Your Ref: OWPC21861
Our Ref: BR/49/19/OUT 13-02-2019
Please ask for:
Mr S Davis

Outline application with all matters reserved for 22 No. new dwellings consisting of 2 No. 1 bed dwellings, 18 No. 2 bed dwellings & 2 No. 3 bed dwellings.

26 Burnham Avenue Bognor Regis

Thank you for your internet representation made on 27th March 2019 which has been recorded as '**an objection**' with the comments as follows:

Roof / Site Plan (Proposed) 1:200

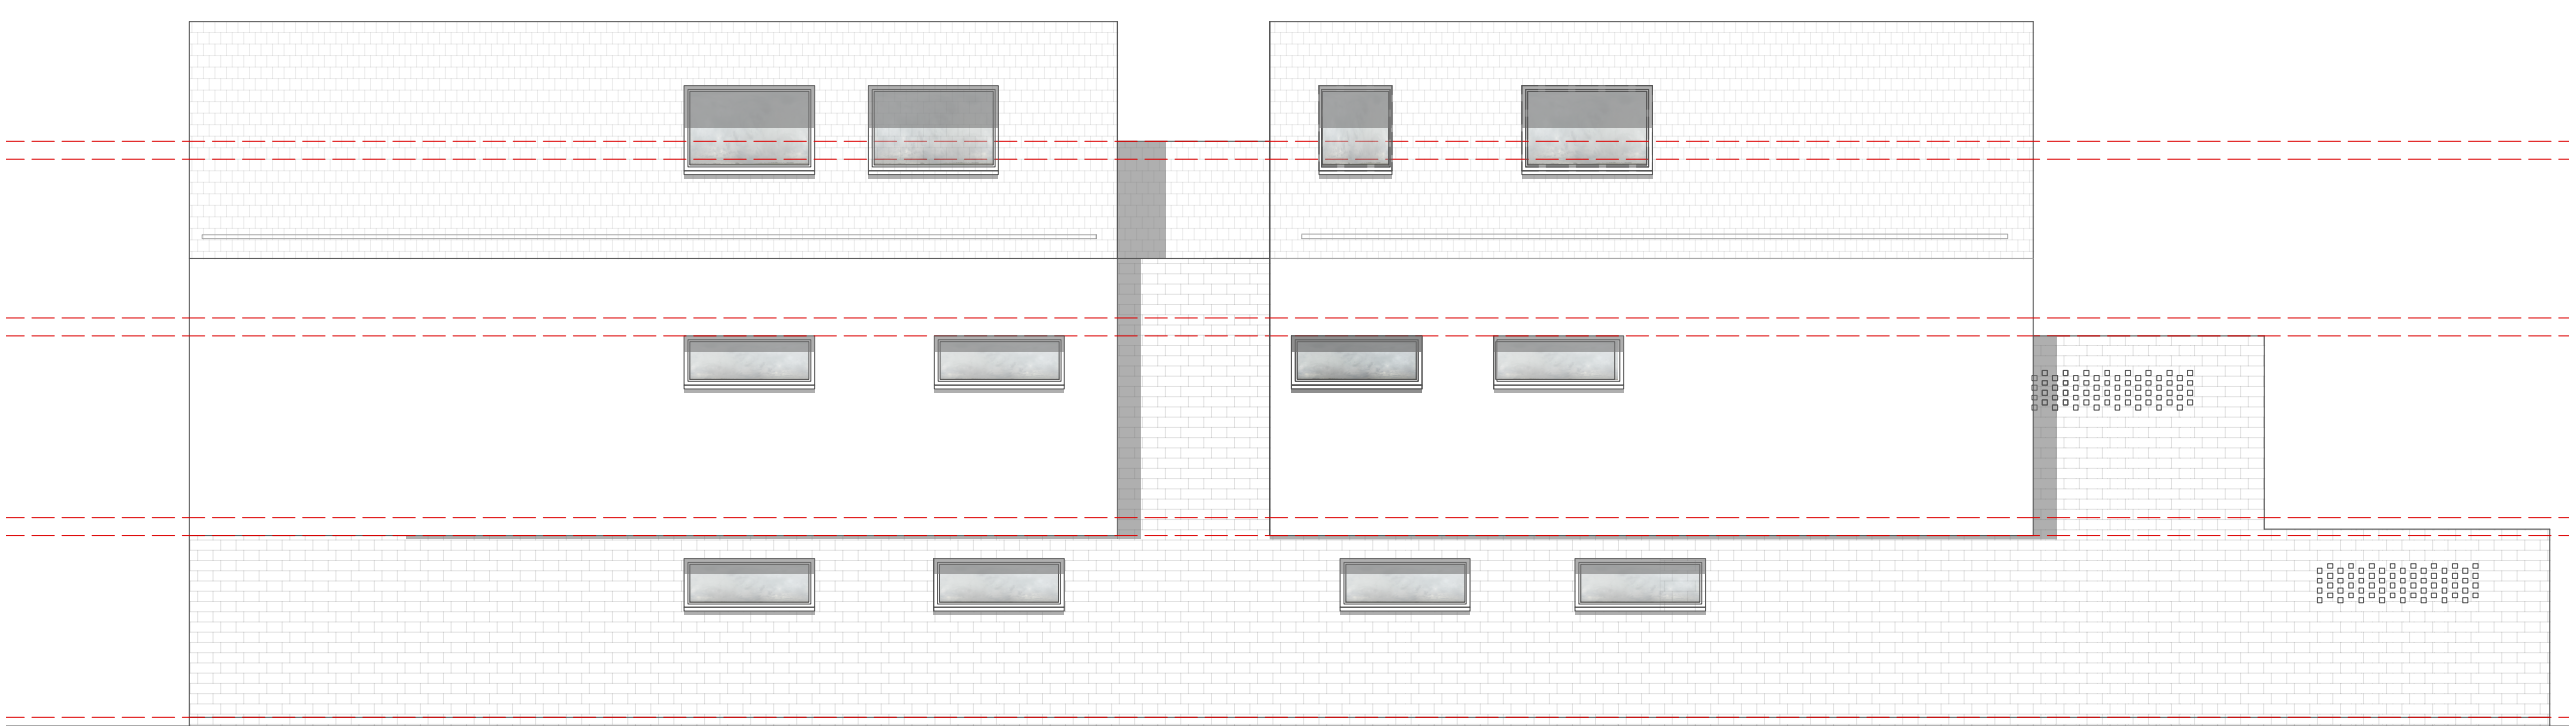
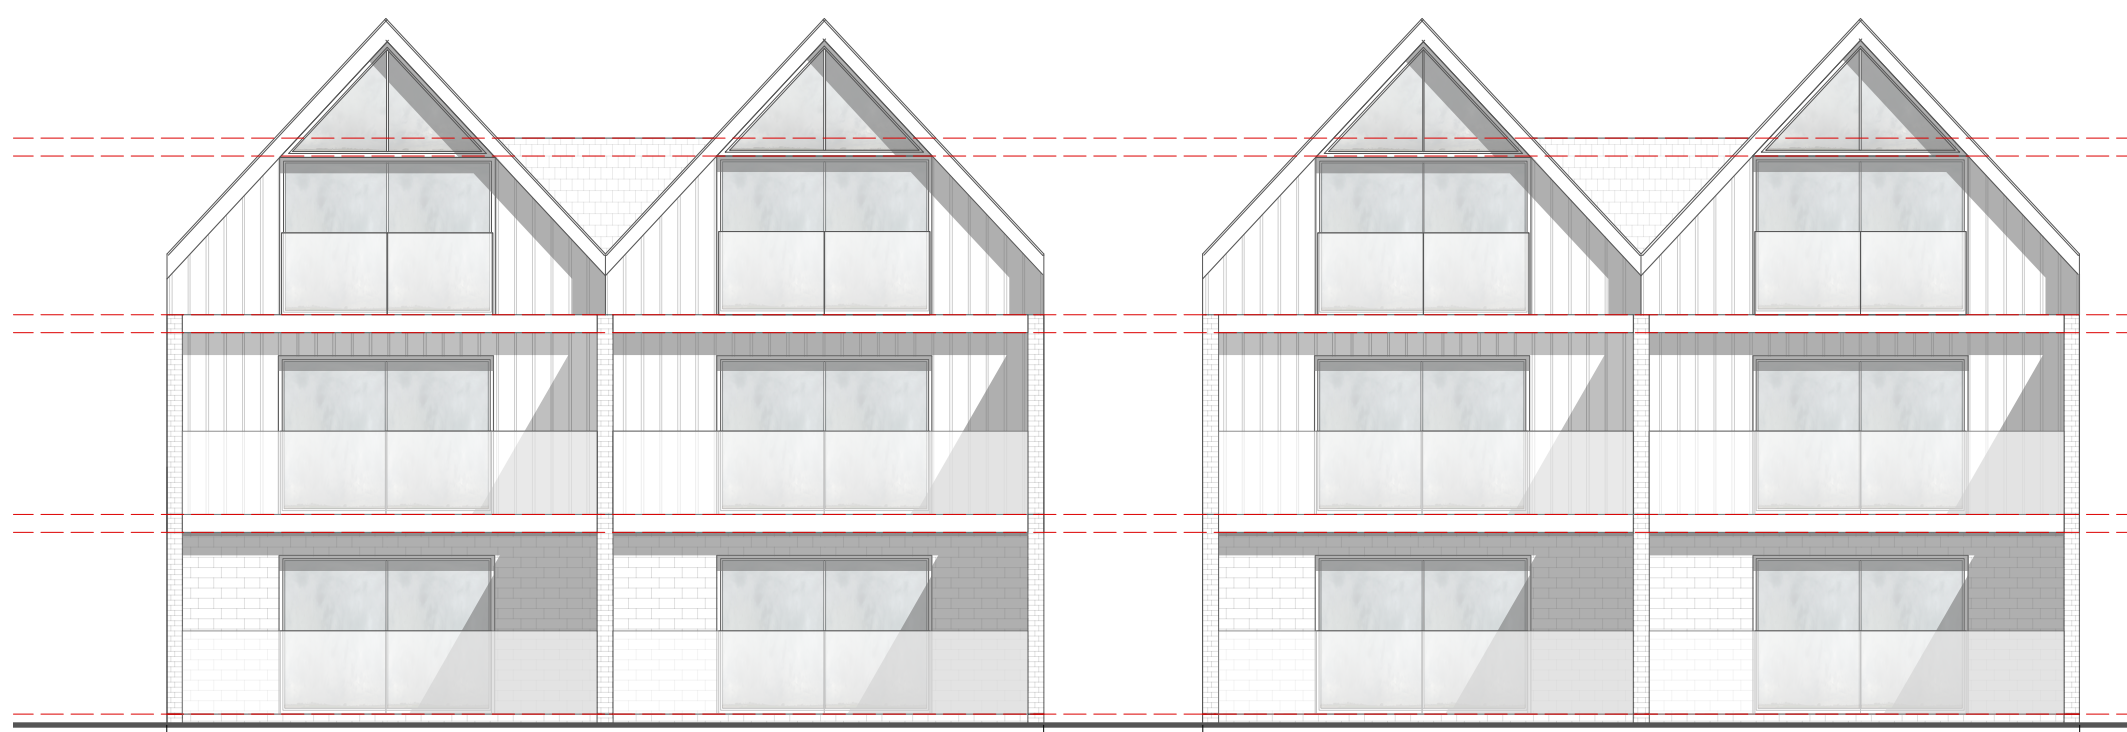
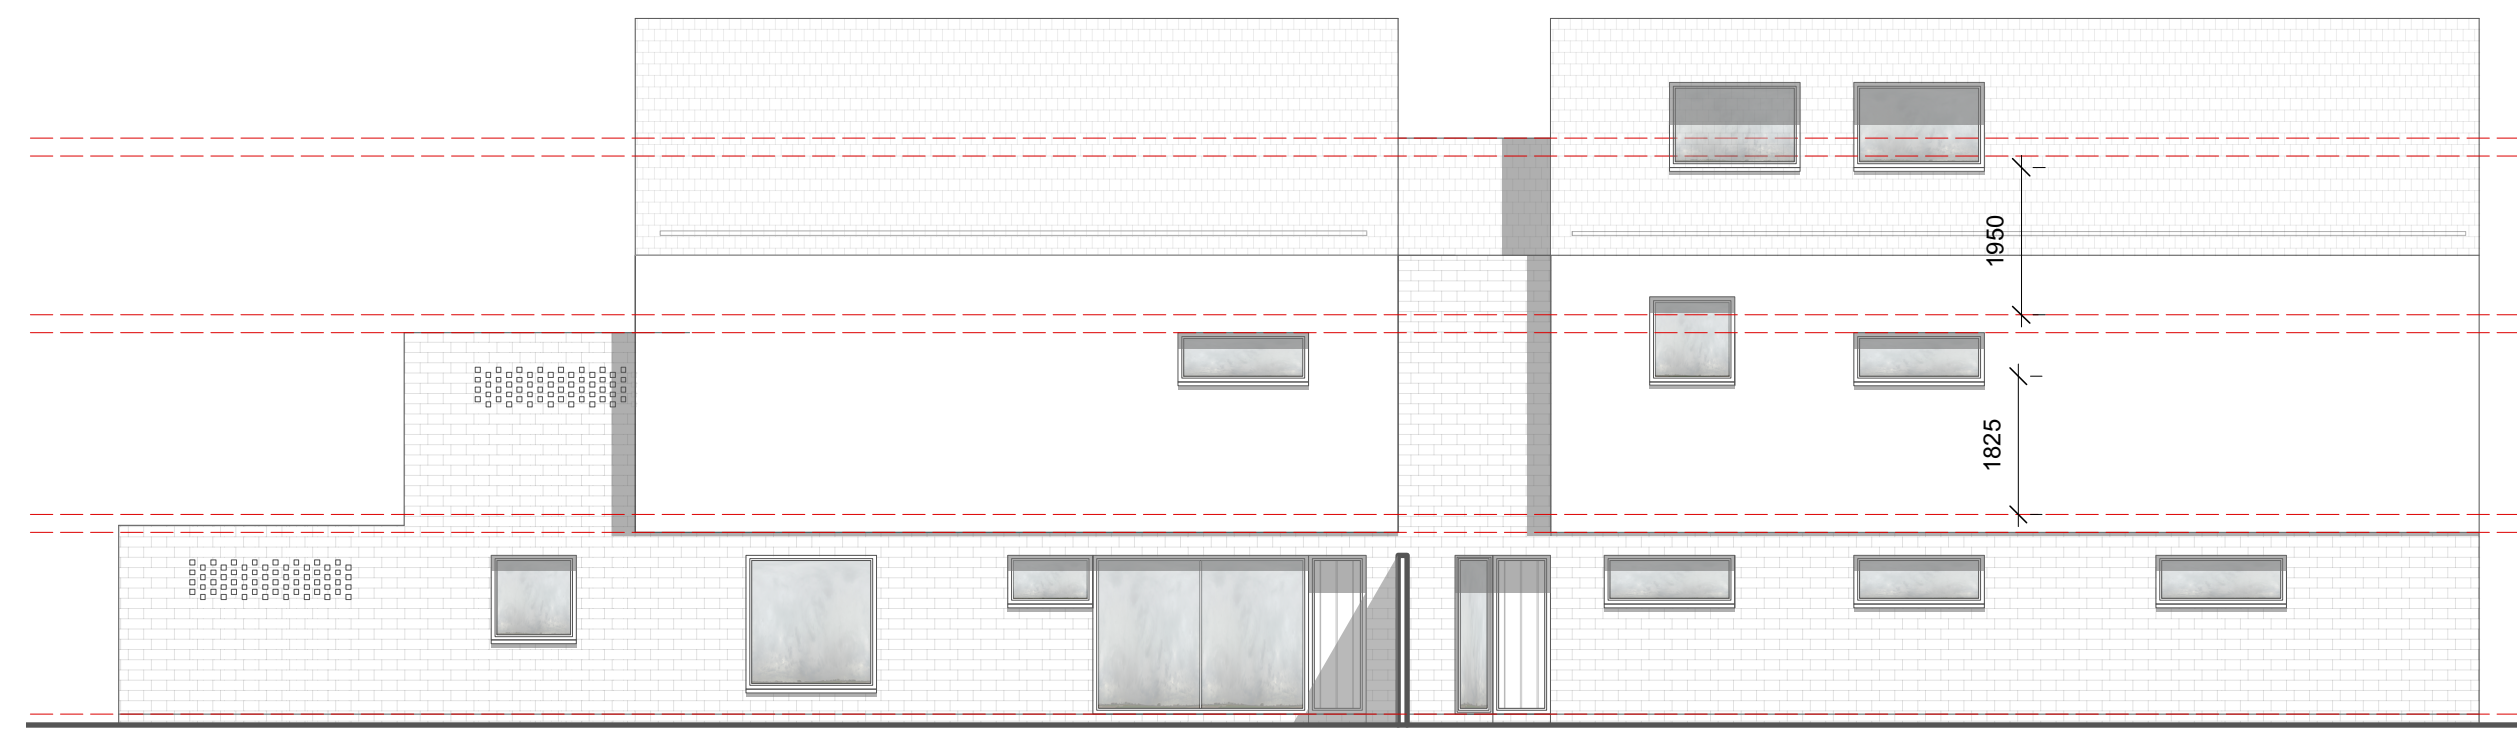
The 3 storey building will overlook Burnham Gdns and is unacceptably close to No.1&2 and Brackley, with all privacy to their gardens totally lost and proposed buildings will greatly affect the sunlight to those properties.

This is over development in a residential area. The plan lacks any parking spaces for these flats, so will lead to them looking to park in the adjacent roads that are already crowded with cars most days.
